Response to Examiner's Questions.

Prepared by	Lucy Baxter (Senior Planning Officer) Elizabeth Verdegem (Team Leader (Strategic) – Development Management)
Date	December 2025
Purpose	Response to ExQ2 for Green Hill Solar Farm (PINS reference EN010170)

- 1.1 This report sets out MKCC's response to ExQ2, issued 28th November 2025, due 17th December 2025.

Title:
Figure 8.1.5 Site Locations and Study Area
Green Hill G

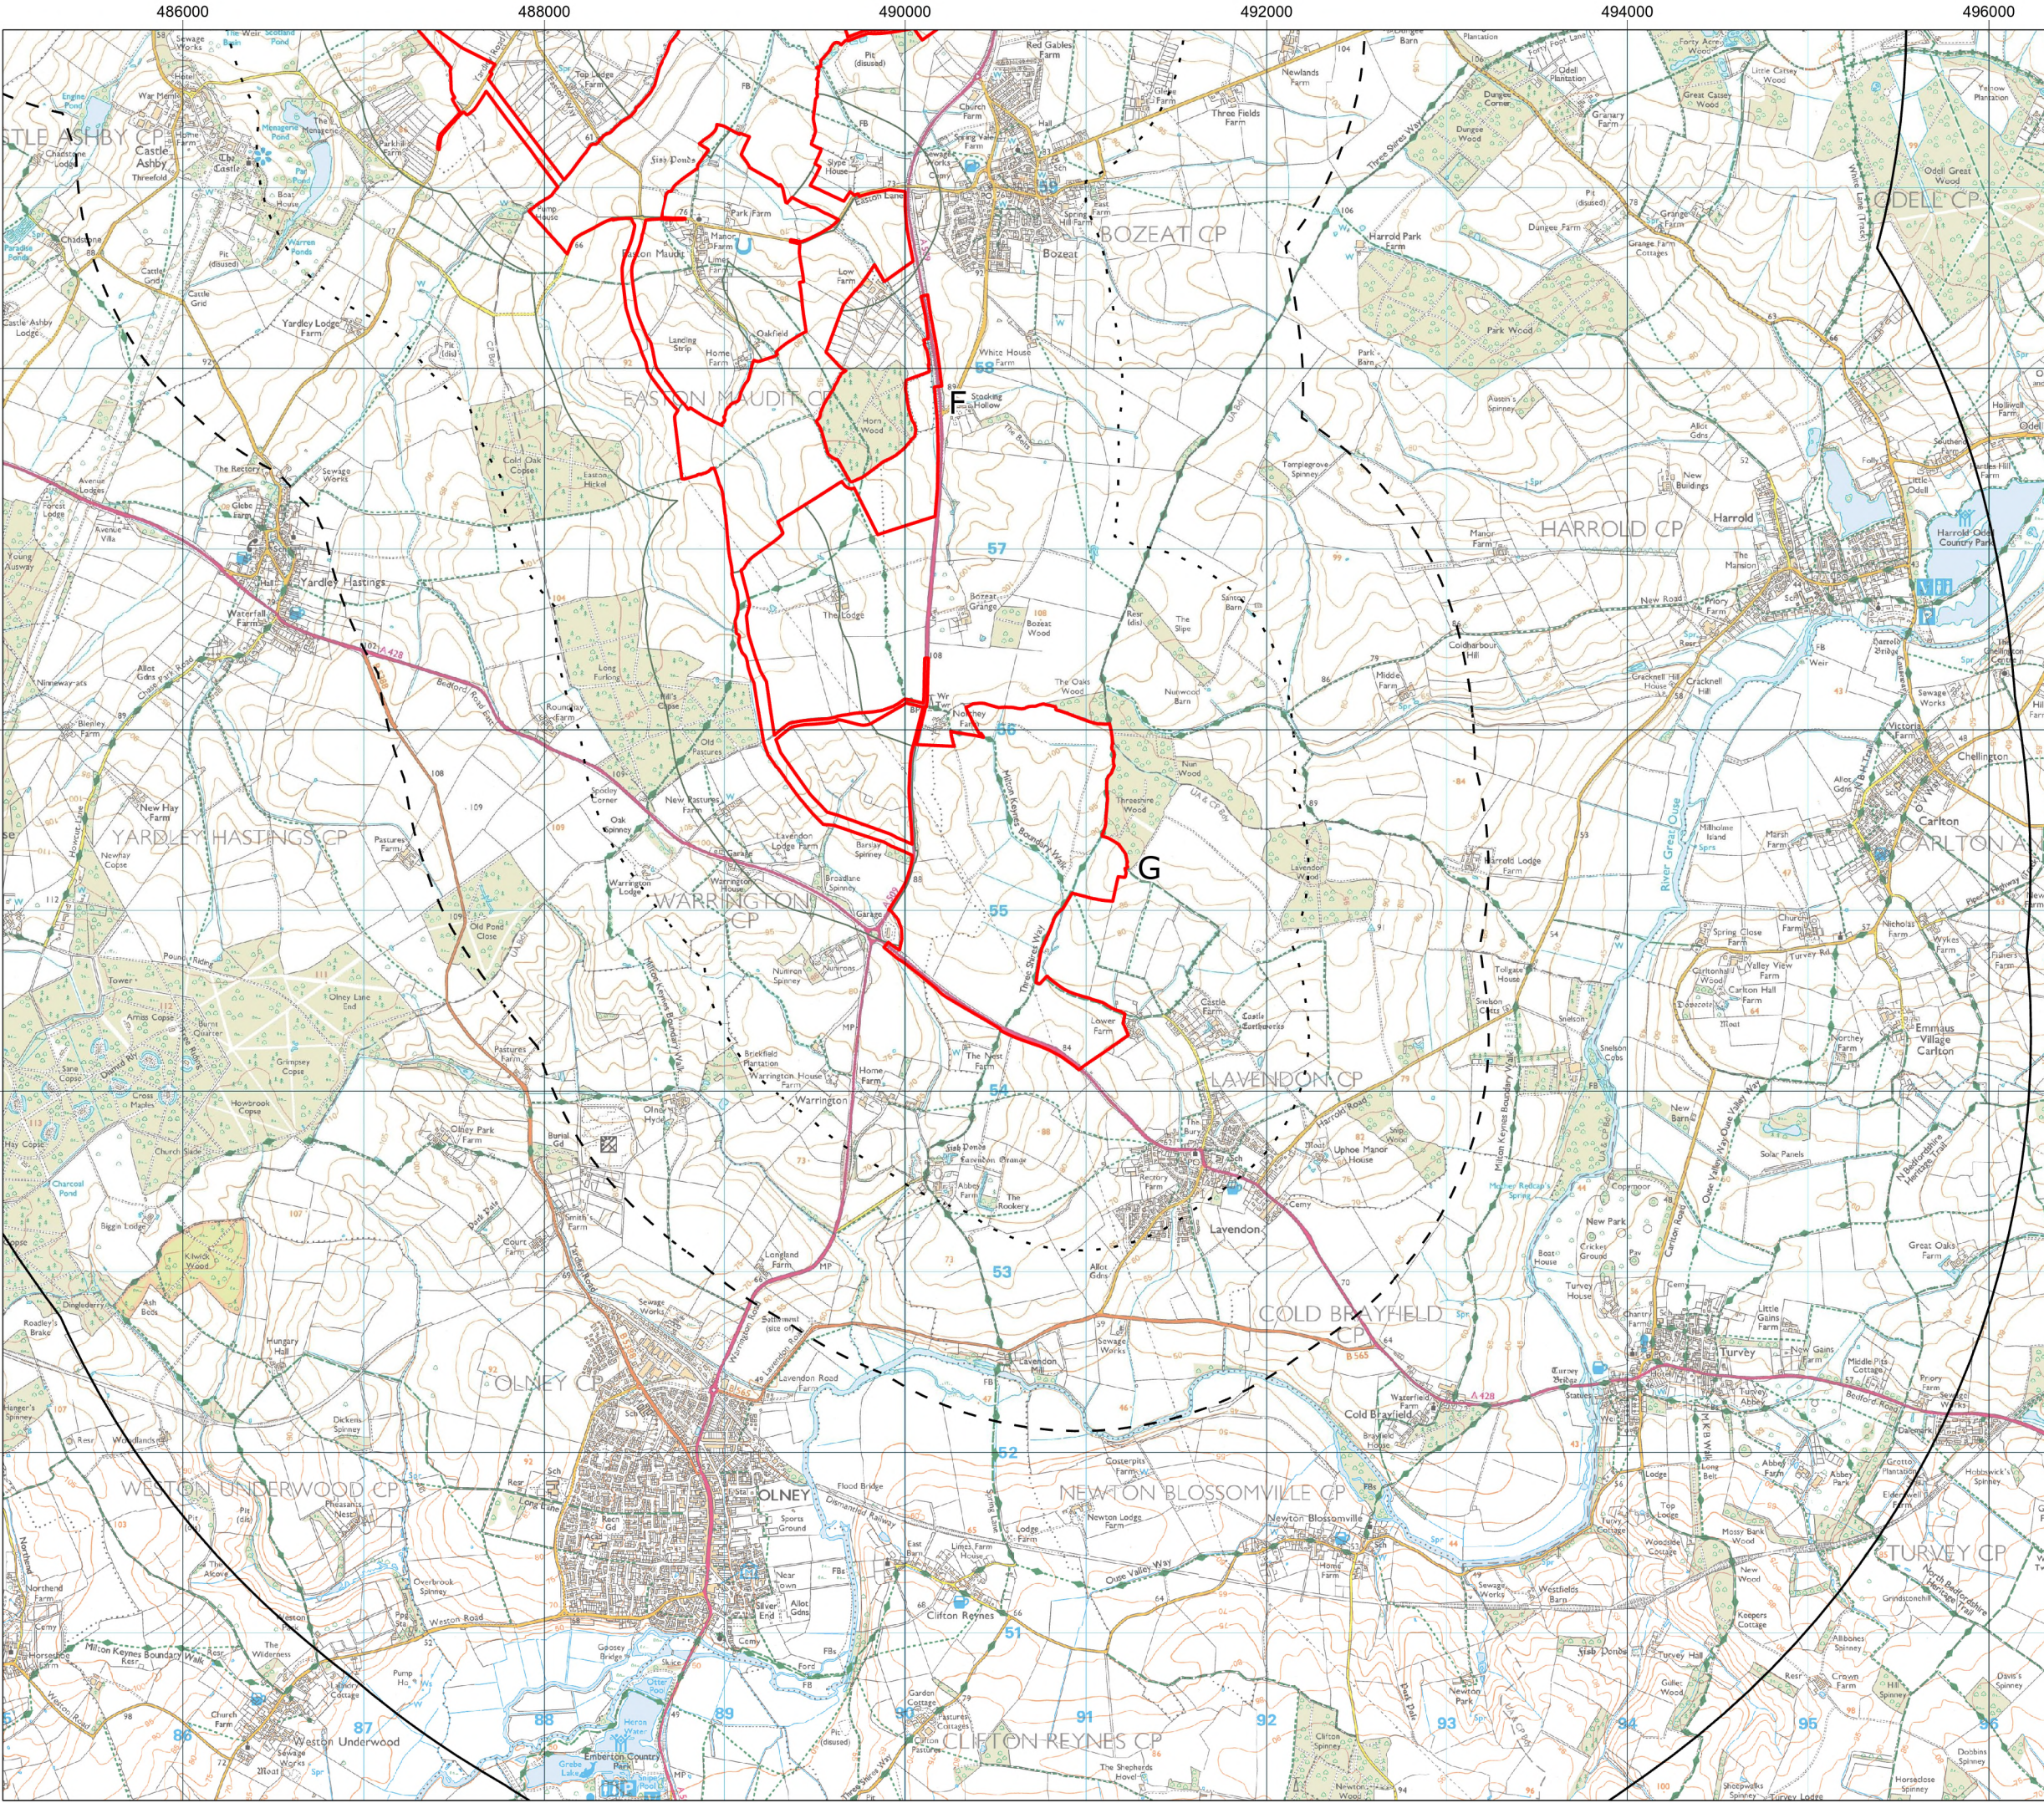
In MKCC, the solar farm proposal will extend up the slopes to the local authority border at Northey Farm, East to Three Shire Wood and the Three Shires Way and into two field parcels East of the Three Shires Way assessed as MKCC Special Landscape Area (SLA) and proposed to be covered by the SLA Policy in MK City Plan 2050.

As set out previously, two field parcels of Site G (the GF9 and GF13 field parcels east of Lavendon bridleway BW 15) proposed for solar farm development impinge on land identified as locally attractive landscape Ouse Valley Special Landscape Area in the local plan evidence base document. Their inclusion as part of the solar development would be detrimental to their landscape character.
